Comment for planning application 21/02883/F

| Application Number | <input type="text" value="21/02883/F"/> |
| Location | <input type="text" value="The Bungalow White Post Road Bodicote OX15 4BN"/> |
| Proposal | <input type="text" value="Flat roofed single garage"/> |

PLAN

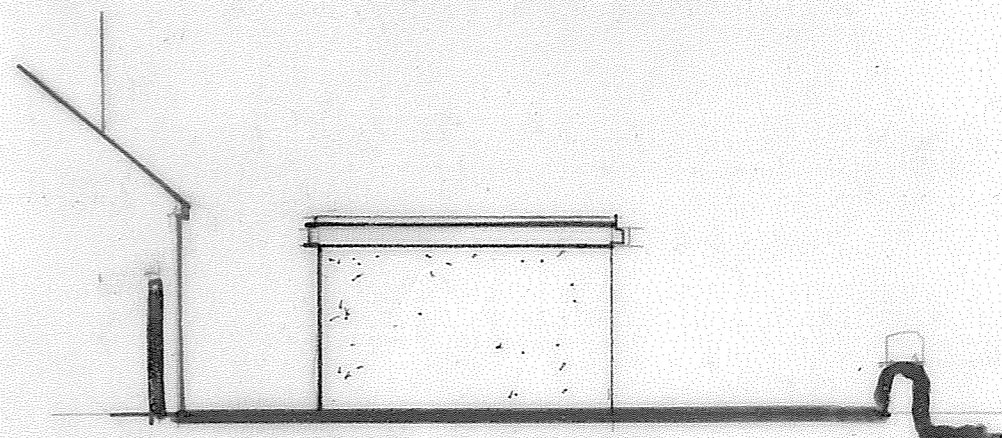
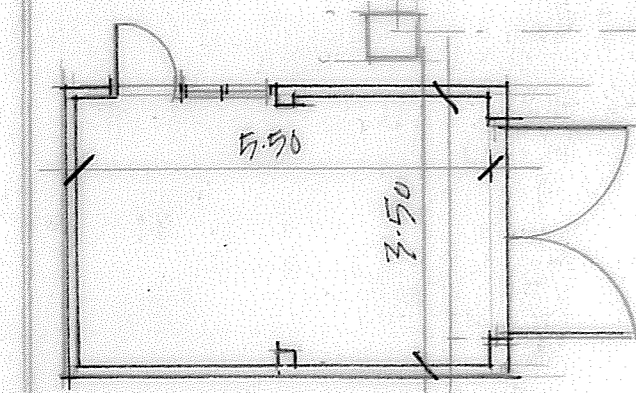
| Comments | <input type="text" value="I have reservations about the proximity of the proposed development to the boundary fence and the impact the foundations will have on established tree roots. The proposed construction is within 2 metres of a listed property and is located within a conservation area, therefore the design must be in keeping with neighbouring properties. I am also concerned about the potential security threat that it represents, making it easy for a would-be burglar to run along the roof and jump into our garden. I would rather see the garage constructed on the other side, next to the village hall car park."/> |
